15 June 2016

Re: Mamre West Precinct, Mamre Road, Orchard Hills
Response to WaterNSW Comments - SSD_7173

As requested we provide this letter which provides a response to a WaterNSW, comments to the NSW Department of Planning and Environment for the above project. The items raised by The Department were provided in a letter (Ref: D2016/4188) dated 31 May 2016 (refer enclosed).

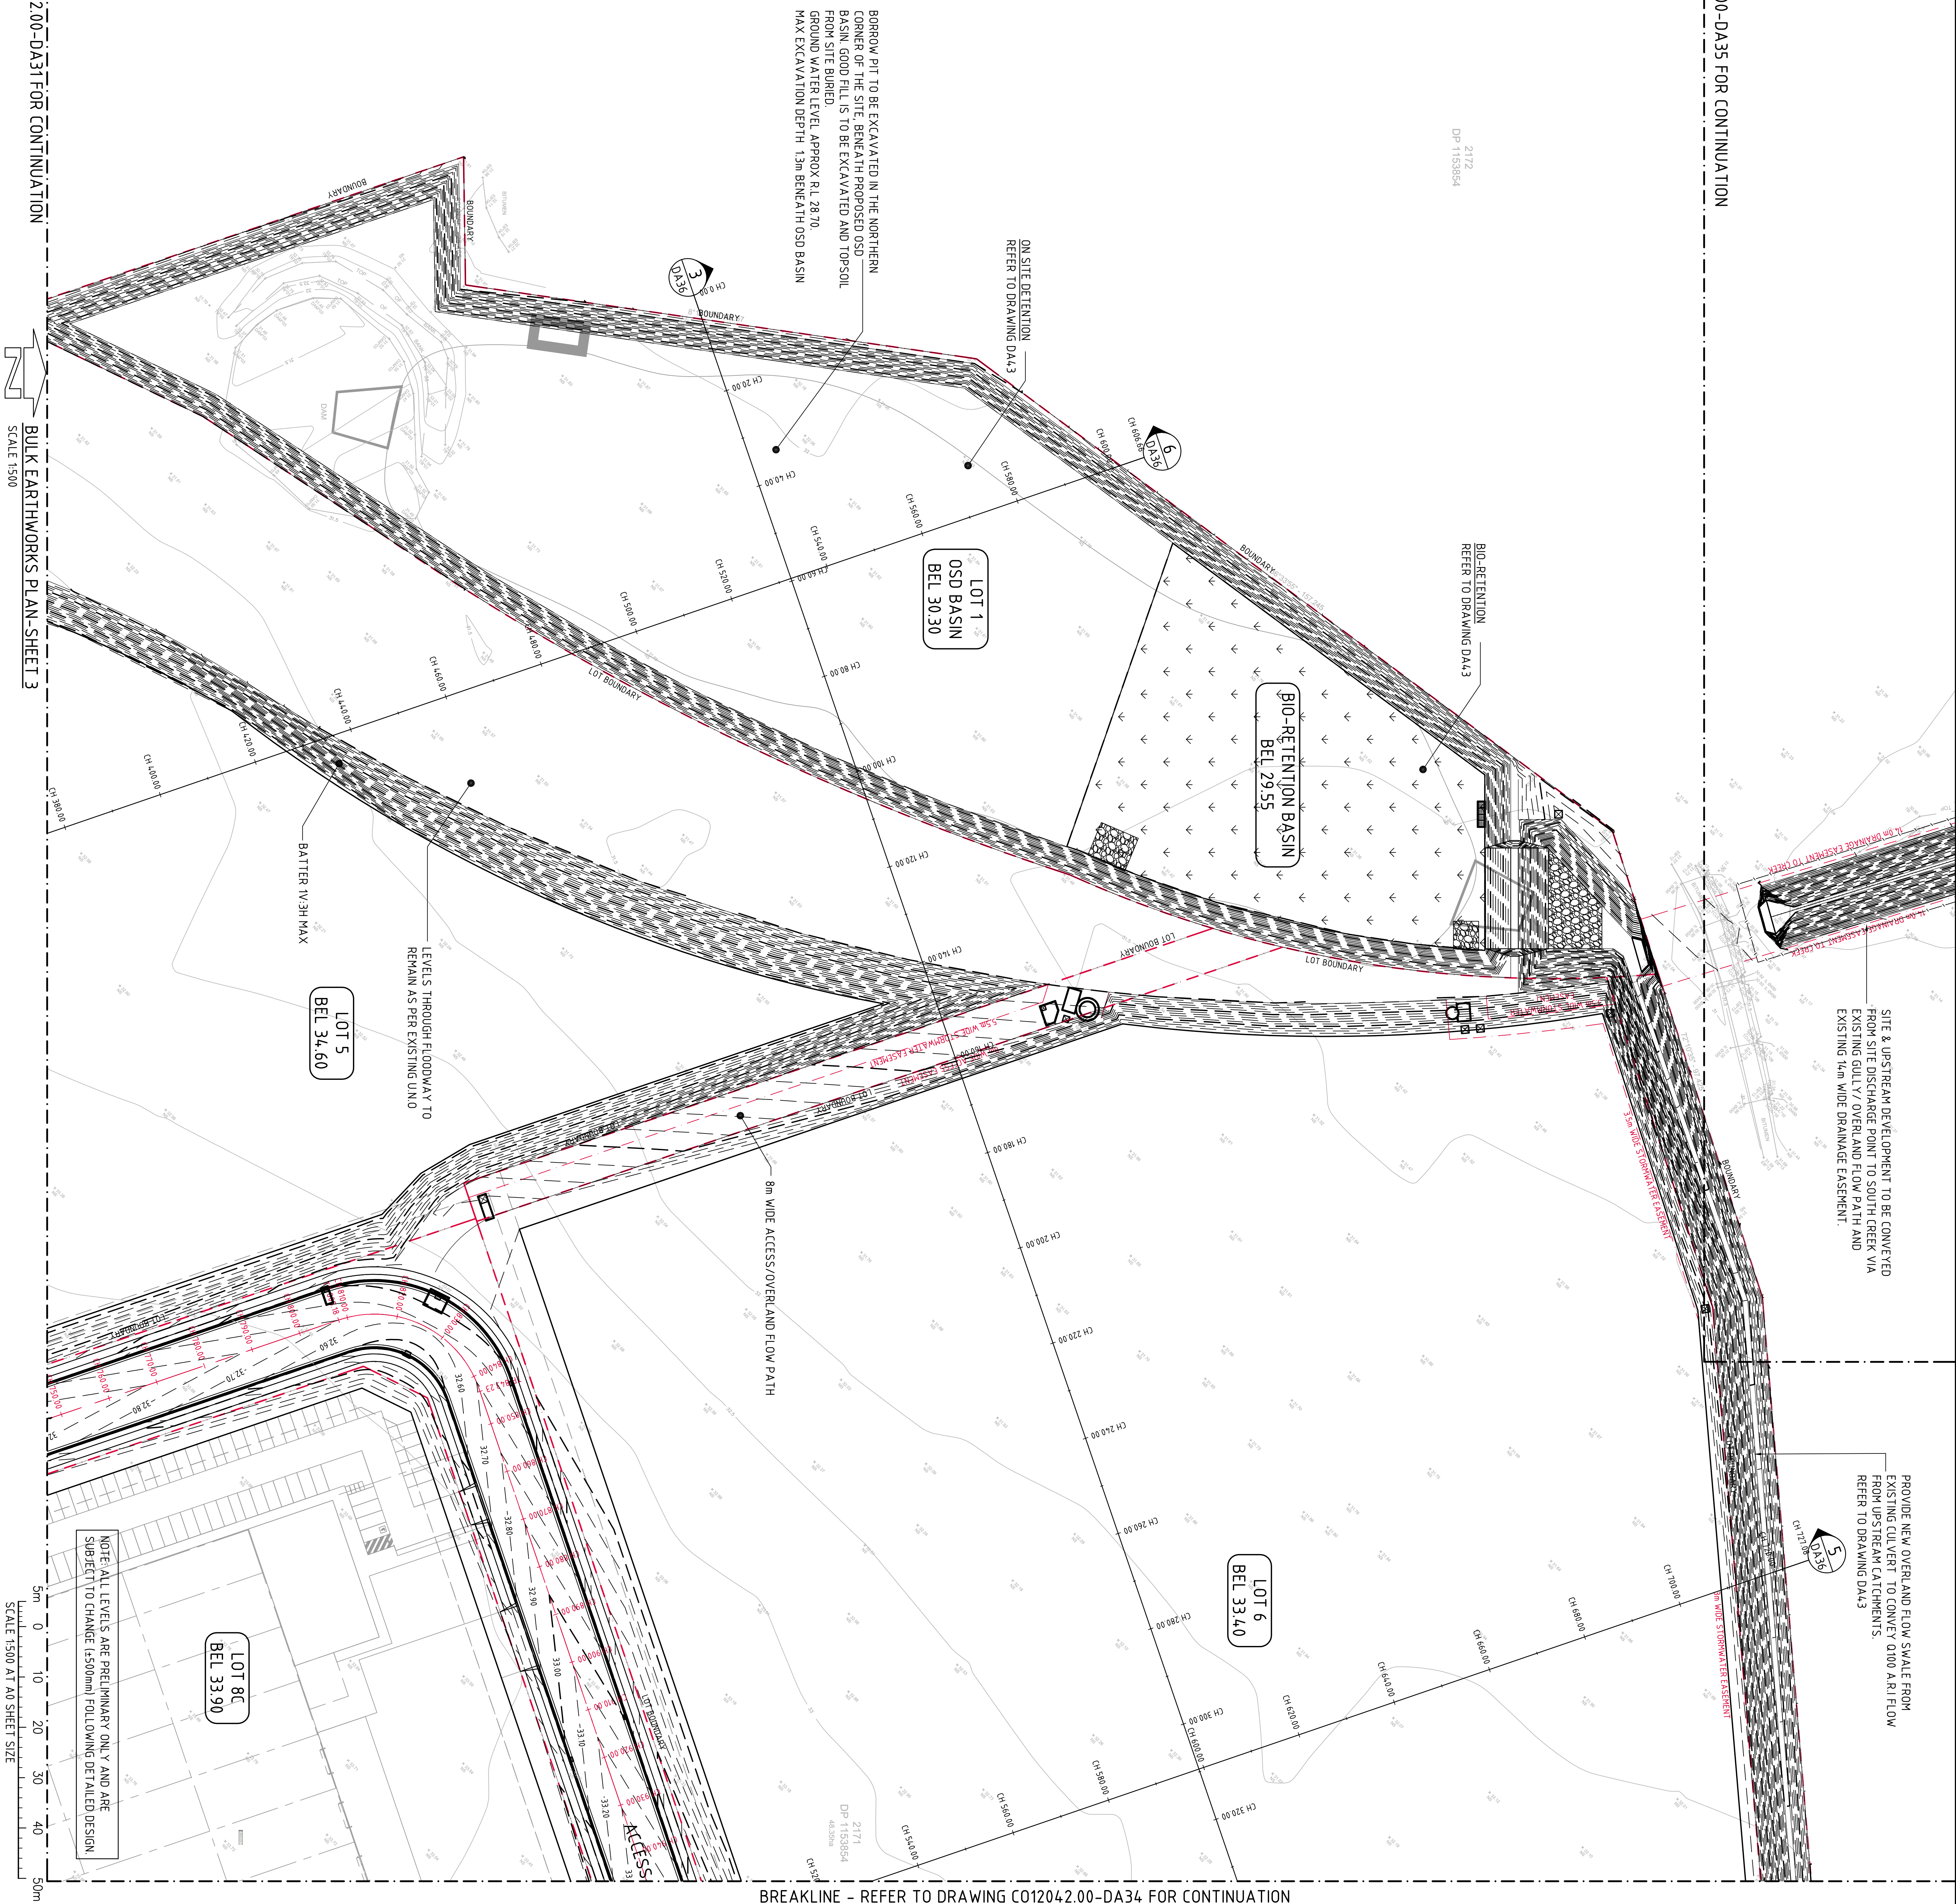
- Item 7 The southwestern corner of the proposed development described as Block 4 is shown in the bulk earthworks cut and fill plan (Drawing: C012042.00-DA30 Bulk Earthworks Cut/Fill Plan) as being subject to a borrow pit. WaterNSW notes that this area was originally excluded from development as a result of flood concerns, and is currently used to convey stormwater from the Pipeline corridor. WaterNSW requires that the flow of stormwater from the Pipeline corridor must not be impeded or caused to flow back to the corridor.*

- Item 9 The proposed development includes earthworks that will result in an elevated batter along the boundary between the Pipeline corridor and the proposed development. The Pipeline corridor contains a raised berm that acts to direct stormwater from the subject site away from the corridor to existing drainage depressions. It is understood that the outcome of the flood studies was to require a portion of the land proposed for rezoning and development, specifically in Block 4, to be left undeveloped for flood management purposes. However, as the Pipeline corridor is not included in these assessments it is not clear what the impact of the development is on flood regimes. WaterNSW requests the consideration of the impact of the proposed development on flood regimes for the Pipeline corridor.*

In addition it is understood that this same area is to be subject to works for the purposes of use as a borrow pit. As the construction of the borrow pit is not included in the flood assessment and the EIS and its associated documents do not contain information on the management or final plan for this area it is not clear what impact the proposed works may have on the flood regimes for the Pipeline corridor.

All works over the estate and within flood ways will be completed in accordance with the 'Overland Flow Report' (Stages 1 & 2), submitted 20th April 2016, as endorsed by Council via email from Nicole Dukinfield 16th May 2016.

We confirm that any works in the above noted area will be completed in accordance with the requirements of the Overland Flow Report, Penrith Council Policy. We confirm that flow of stormwater from the Pipeline corridor will not be

All works over the estate and within flood ways have been designed and will be completed in accordance with the 'Overland Flow Report' (Stages 1 & 2), submitted 20th April 2016, as endorsed by Council via email from Nicole Dukinfield 16th May 2016.

We confirm that the study area and flood model extends 400m to the south of the

estate property boundary and includes the Pipeline Corridor. The study shows that the inclusion of the filling and batters on the southern boundary does not affect or impede flows within the pipeline corridor, as defined in Section C3 of Penrith City Council Development Control Plan. Further we advise that a Sensitivity Assessment was completed which extended to the modelling for a distance of 2500m upstream of the estate boundary which confirmed the model outcomes as noted above.
